Re Submission to exhibition of SSD-82709458 at 19-25 Balfour Street, Lindfield

We write on behalf of the owners of Nos 8 to 14 Highfield Road, Lindfield (“**our clients’ property**”) in relation SSD-82709458 at 19-25 Balfour Street Lindfield (“the development site”). Our clients’ property adjoins the site to the north and shares a common rear boundary with the development site. The relationship between our clients’ property and the development site is shown in the following diagram.

Drawn:
DRIVEWAY DETAILS

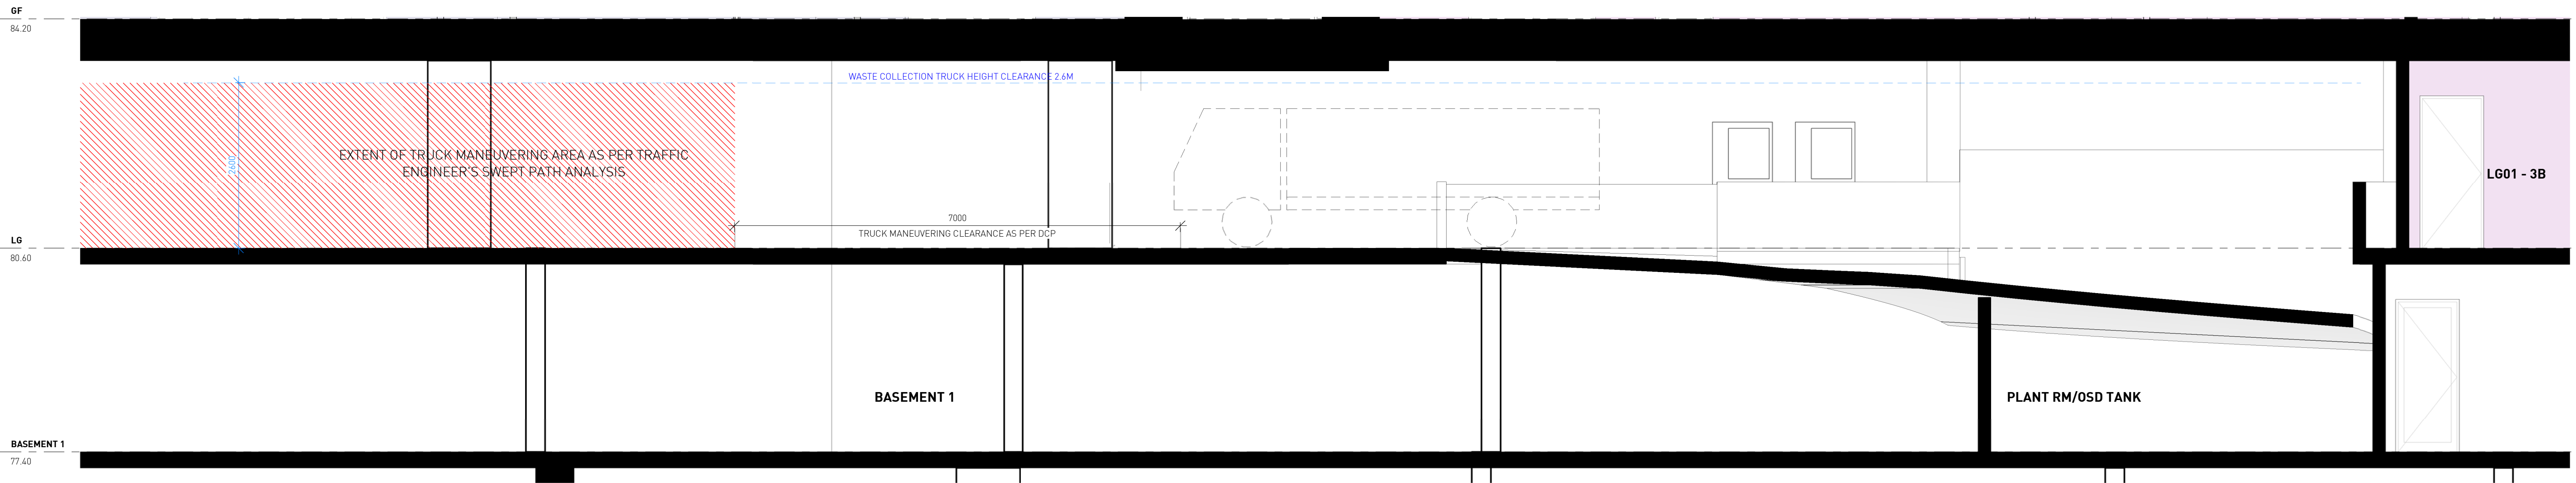
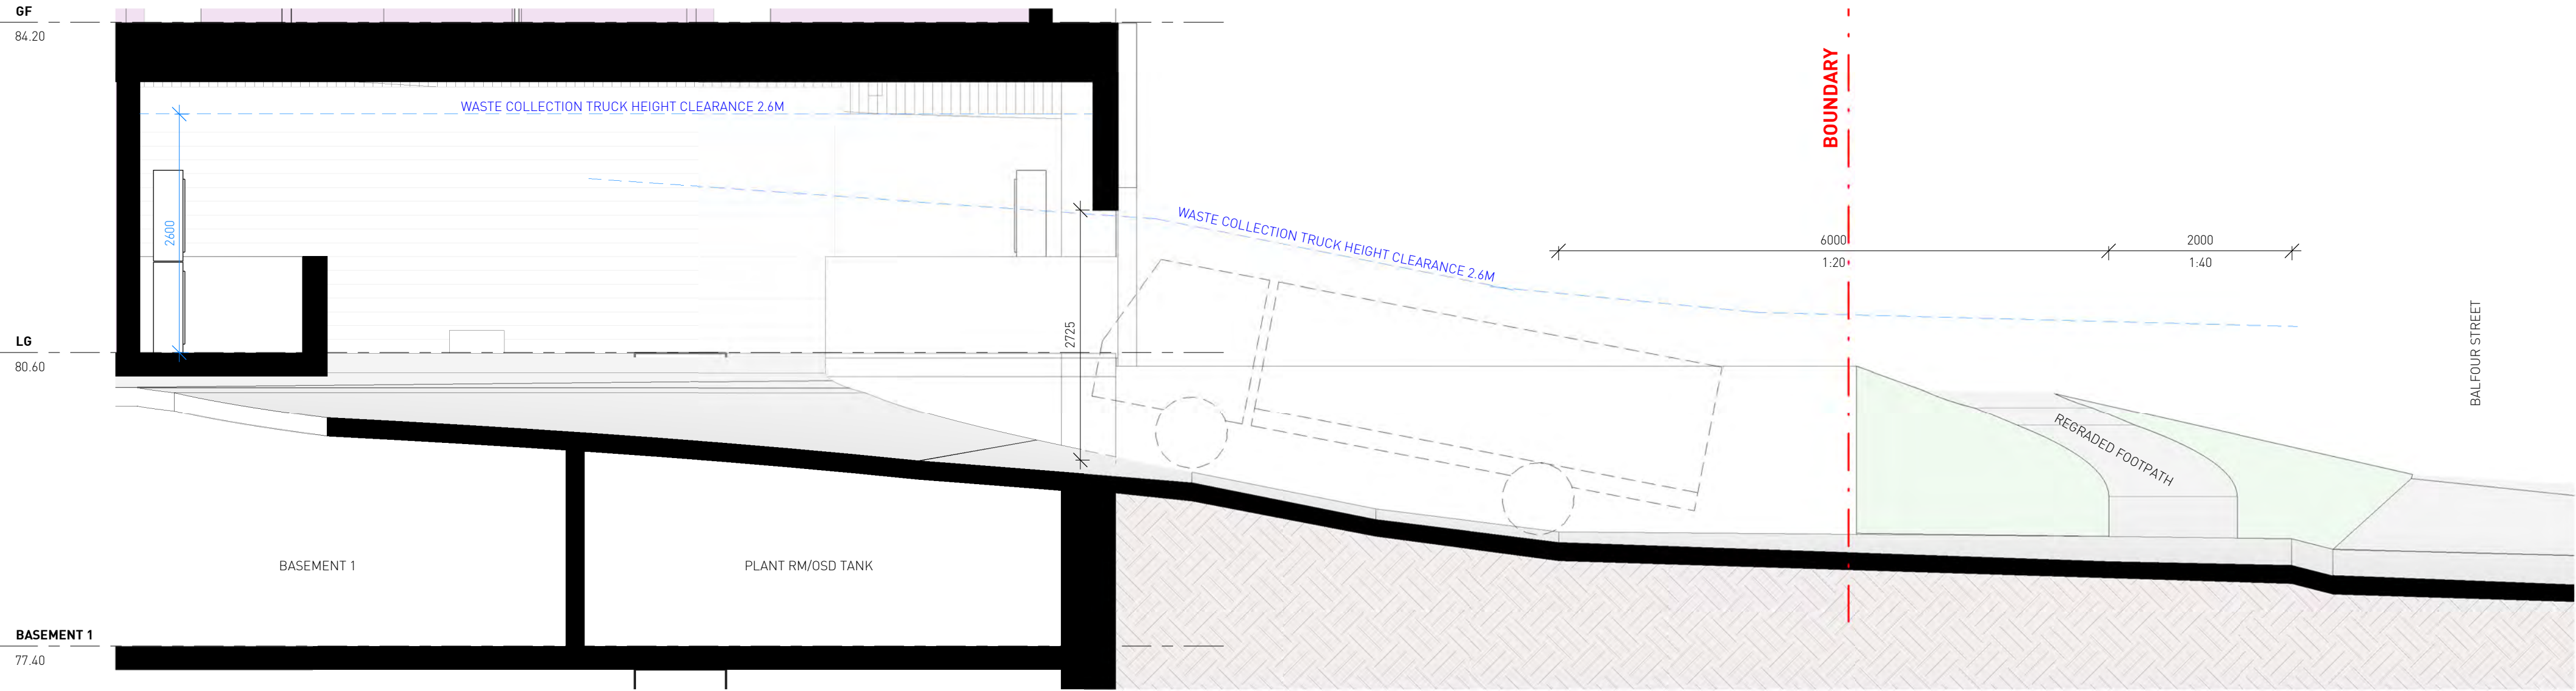
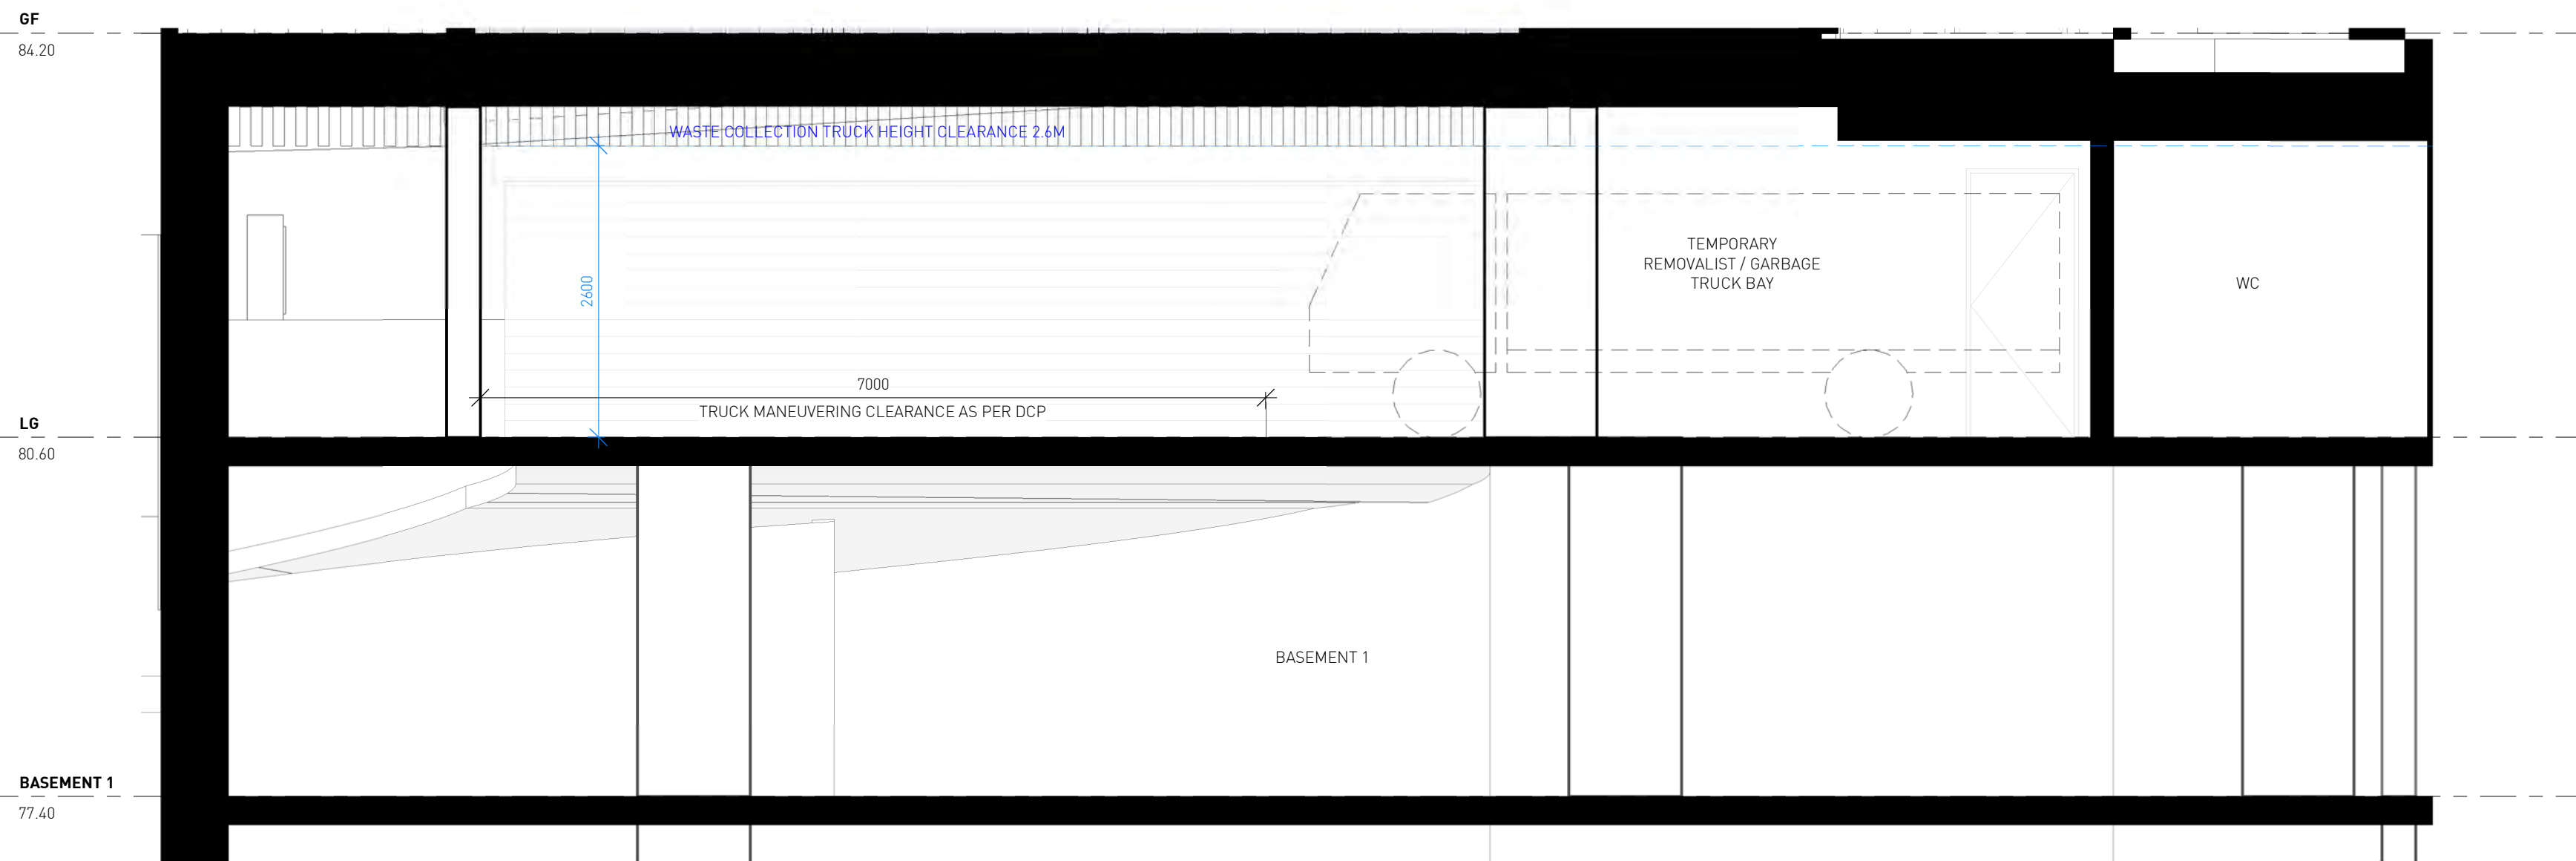
The existing site condition includes a steep rise from the carriageway of Balfour Street to the site boundary. At the location of the driveway the pre and post levels are as follows as shown on the landscape drawings:

Location	Existing RL	Proposed RL	Change (m)
Carriageway at northern end of proposed driveway	78.42	78.46	-
Site at northern end of proposed driveway	80.39	78.65	-1.74
Carriageway at southern end of proposed driveway	78.71	78.115	-0.6
Site at southern end of proposed driveway	79.97	78.365	-1.6

The drawings also show that the existing footpath will be regraded reducing in height from RL79.74 to RL78.60 in the vicinity of the driveway. It is clear that there will be significant changes to the levels of the verge between the existing carriageway and the site boundary to provide access to the site and to provide an accessible pathway. This is likely to significantly affect the topography and vegetation on the street verge and require further changes including retaining walls and or batters on Council property. Approval for these works should be obtained from Council. Full details of these works should be provided.
